Our ref: 23_25898_P

Site Location: Land between A16 and Rangell
Gate Spalding

Summary of Proposal: Proposed
Anaerobic Digester Plant

Project PROPOSED AD PLANT		
Address NAYLOR FARMS RANGELL GATE, SPALDING LINCOLNSHIRE		
Client NAYLOR FARMS		
Drawing PROPOSED SITE PLAN VISIBILITY SPLAY - 2.4M X 120M		
Date FEB 2024	Scale 1:1000 @ A1 - 1:2000 @ A3	
Project No. 3899B	Drawing No. P05	Revision

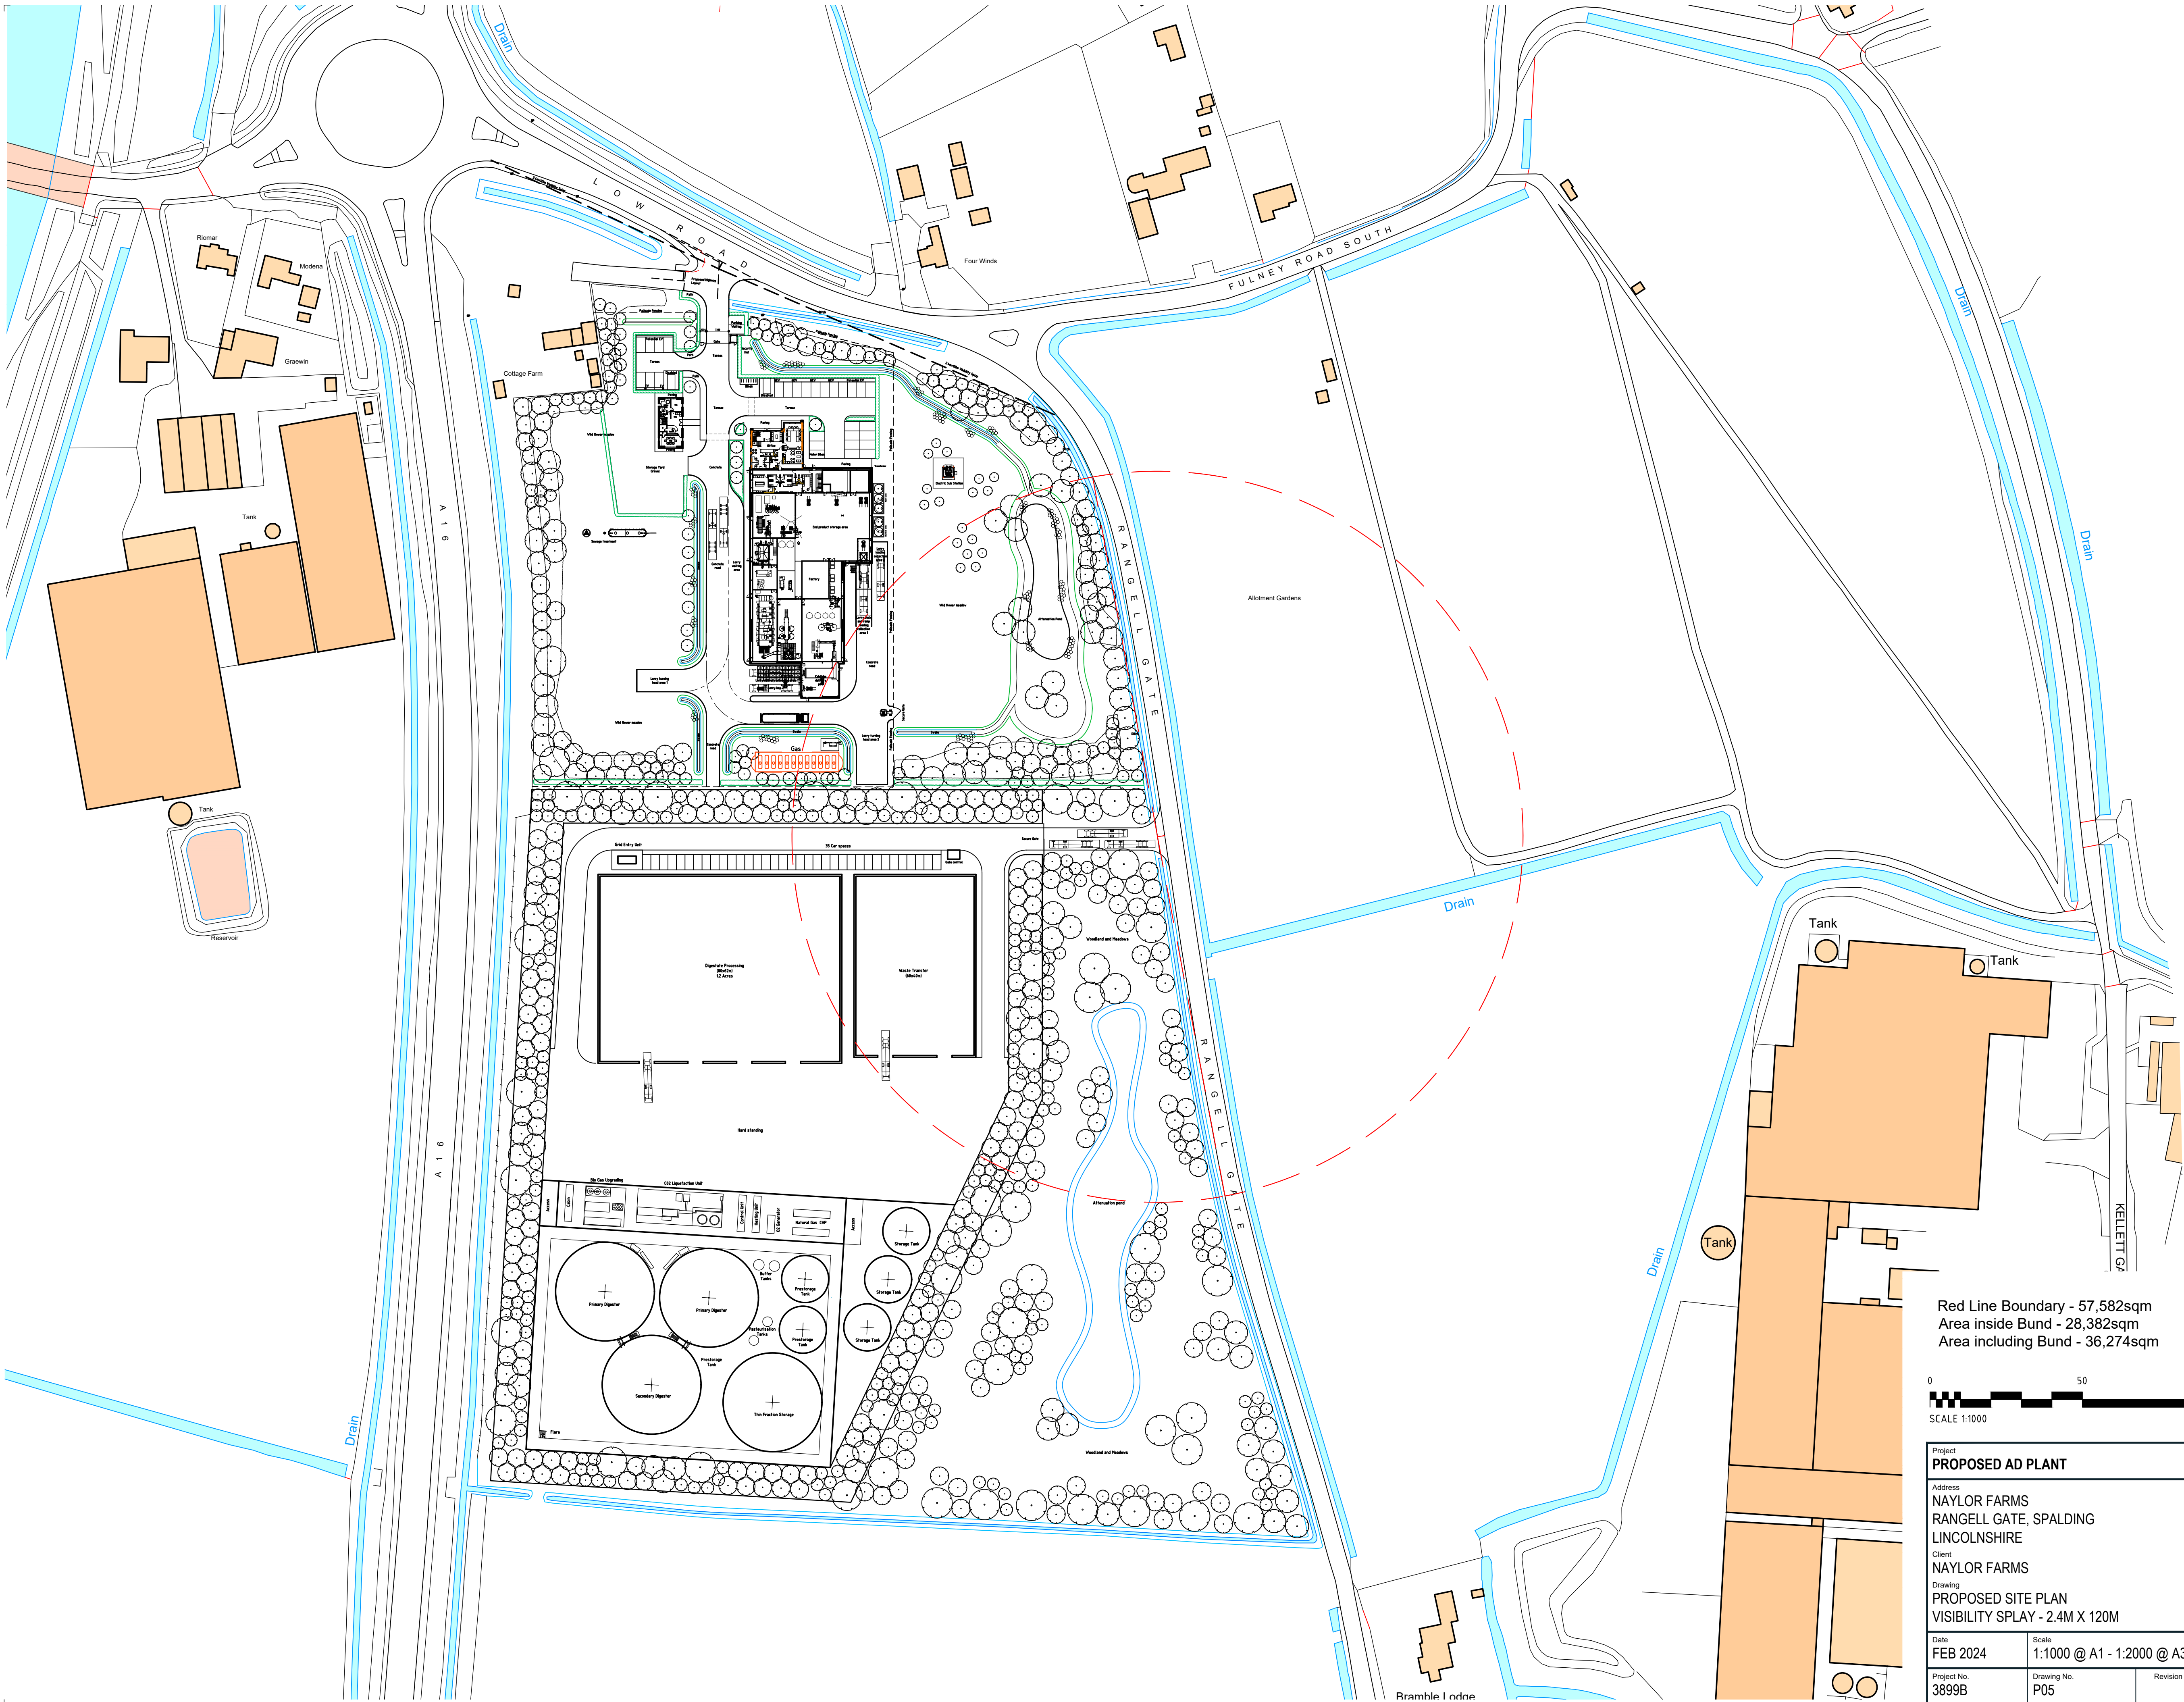
I note the site is surrounded by riparian watercourses which are not maintained by the Board (ordinary watercourses), adjacent to each site boundary. I note that the applicant intends to install an access from Rangell Gate to the site (Document Ref: 0371-REP-3000 REV 00, Jackson Consulting Engineers, 21/04/2024).

Whilst the applicant has not provided further details on the proposed access culvert, prior written consent is required from the Board under Section 23 of the Land Drainage Act 1991 (and byelaw 4). The Board requests further information is provided.

In addition to the above, the Board recommends that adequate space (3-5 metres) is left flat and free from obstruction adjacent to the riparian watercourses, in order to enable maintenance by future riparian owners.
